DECISION DELEGATED TO HEAD OF PLANNING

Application No: H08-1023-25 **Applicant:** Mr D Charlton

Proposal: Residential Development comprising 1 new dwelling and conversion and extension of existing agricultural building, demolition of existing agricultural building and proposed new farm access track

Location: Risegate House Farm Hedgefield Hurn Gosberton Risegate

PROPOSED ROOF PLAN
1:100

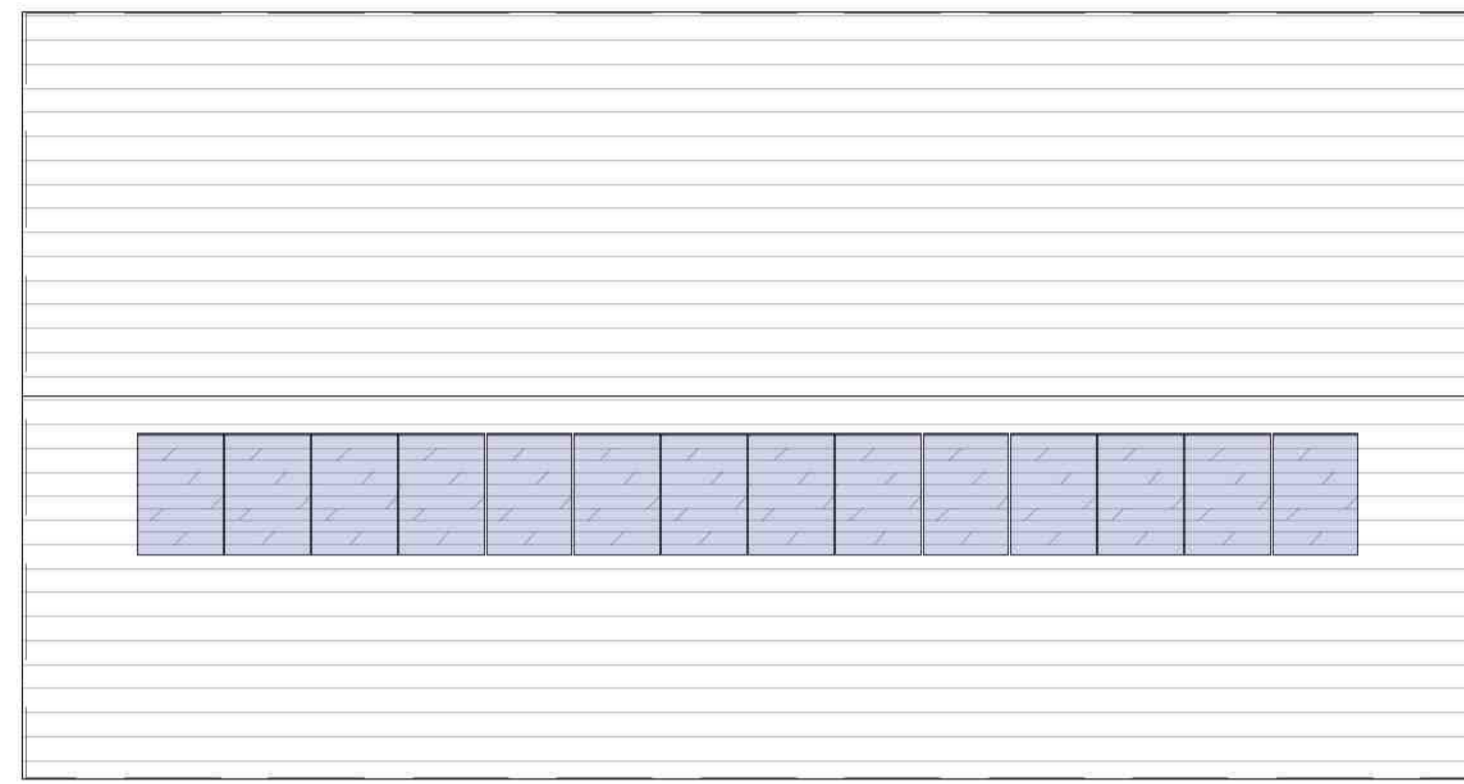
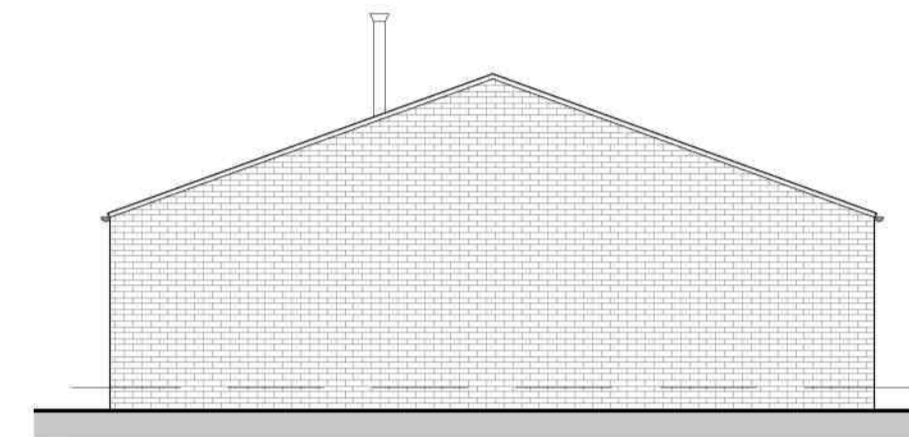
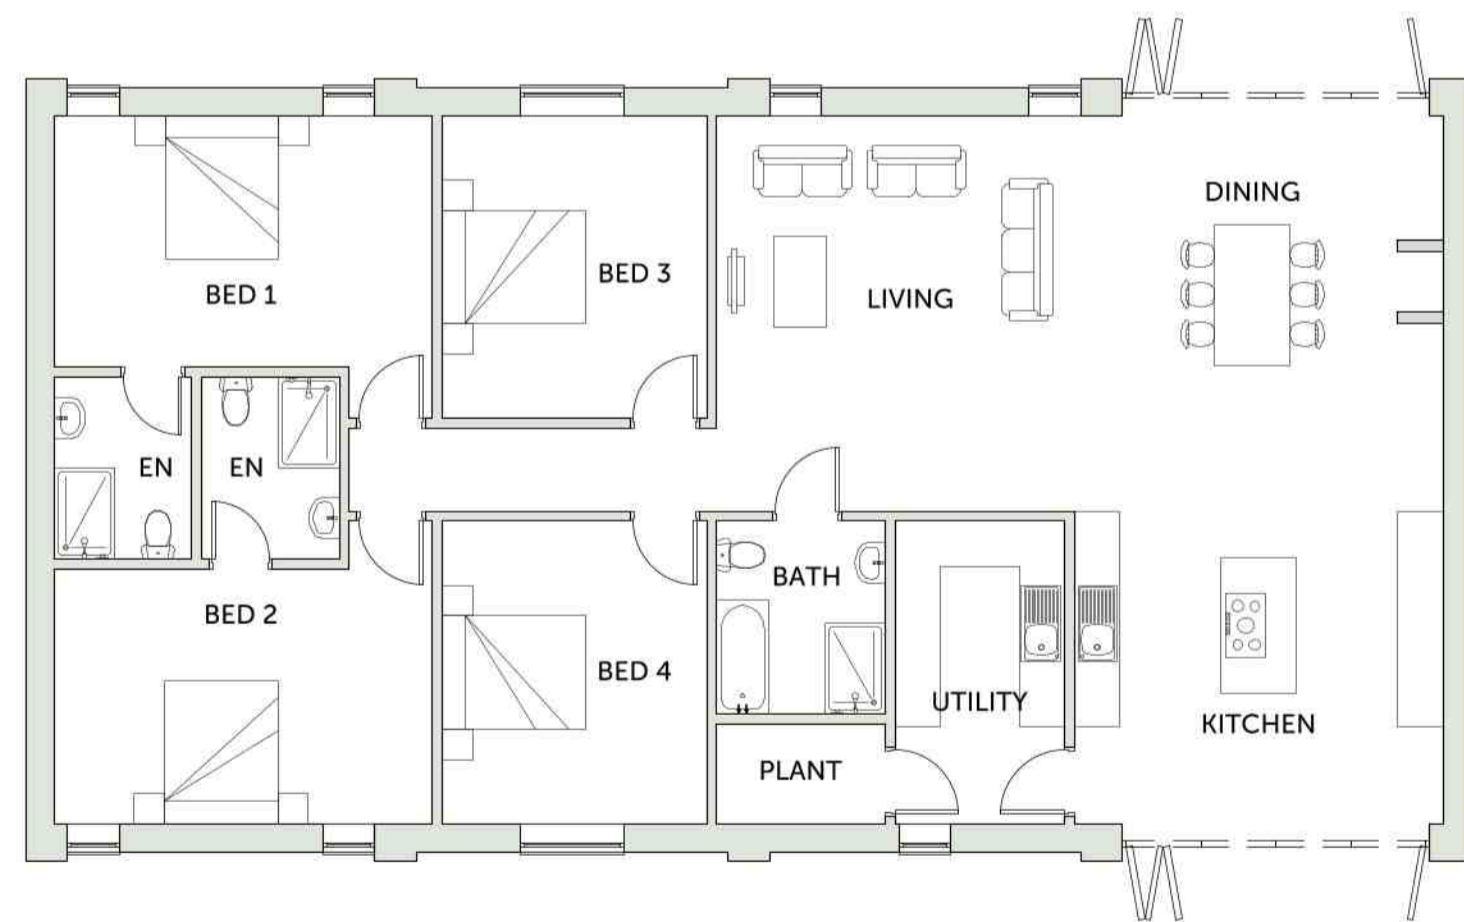
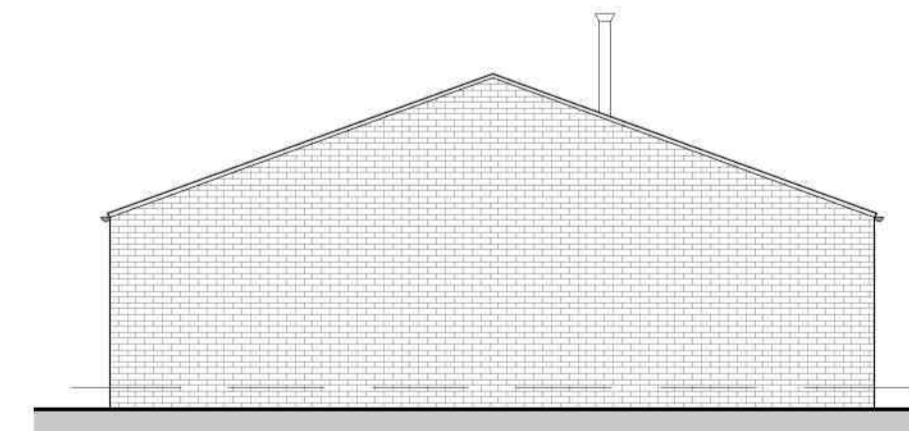
The elevation plans for plot 2 have also been amended during the determination of the application in order to incorporate vertical cladding panels and to include a metal chimney flue rather than a brickwork chimney breast. The updates have resulted in changes to the placement of some of the windows; however, overall the appearance of the dwelling remains similar and it was not considered necessary to re-consult on the proposed changes. The building is proposed to feature a combination of brickwork, timber cladding and a pantile roof. The building is considered to be of a suitable character and appearance for the area. Combined with the siting of the building, it is considered that the proposal represents a betterment over the previously approved Class Q conversion. The proposed materials such as the brickwork and cladding are not yet confirmed. As such, further details relating to the materials would need to be secured via a condition.
